**COMMUNITY SERVICES DEPARTMENT**

**Subject: Grandview Reserve 1041 Permit Application Review – (AASI-21-003)**

PROPOSED 18" SANITARY SEWER MAIN

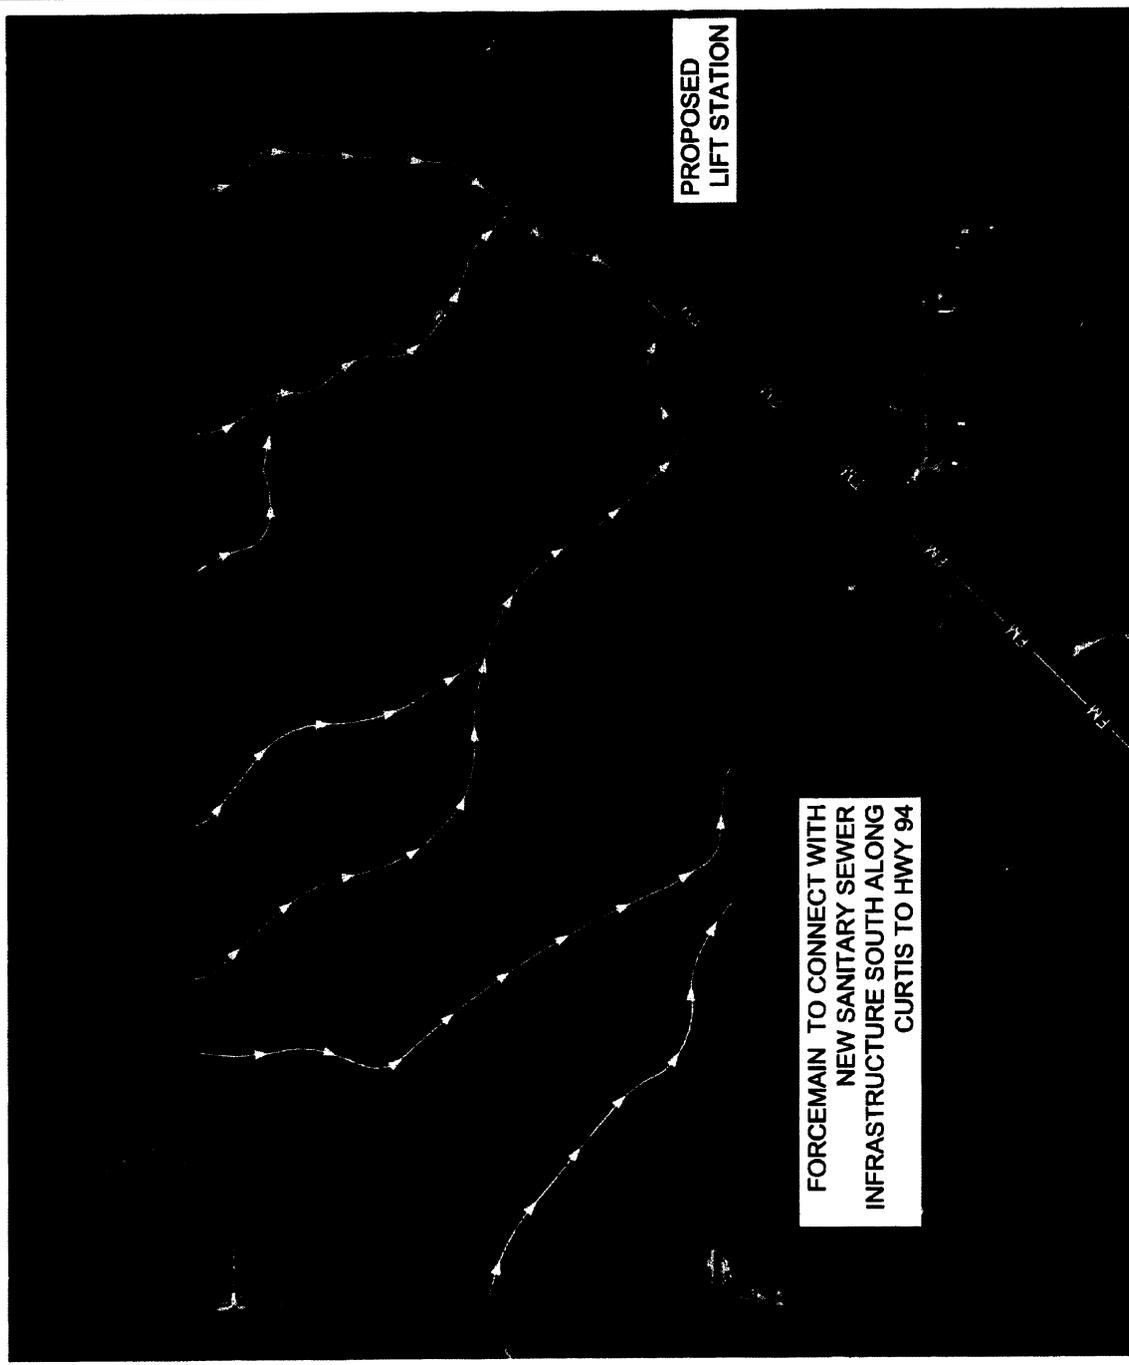
However, the proposed sanitary sewer line, as depicted in the attached schematic, may impact the existing Rock Island Primary Regional Trail, located immediately southeast of Grandview Reserve along East Highway 24. The Rock Island Trail and its associated infrastructure along the site of the former Chicago, Rock Island, and Pacific Railroad has been recognized as historically significant by History Colorado, Office of Archaeology Historic Preservation, and is a major regional trail corridor, extending approximately 8.75 miles from the Town of Falcon to the Town of Peyton.

The applicant has expressed their intent to request an easement within the Rock Island Regional Trail corridor property, which is owned in full by El Paso County Parks, for the purpose of constructing a sanitary sewer line from Grandview Reserve to a point on East Highway 24, north of the terminus of Curtis Road, at a distance of approximately 4,500 feet. When the sanitary sewer line easement request is submitted in full, El Paso County Parks staff will review the plans and application and determine whether a revocable license agreement can be issued for the construction of the sanitary sewer line.
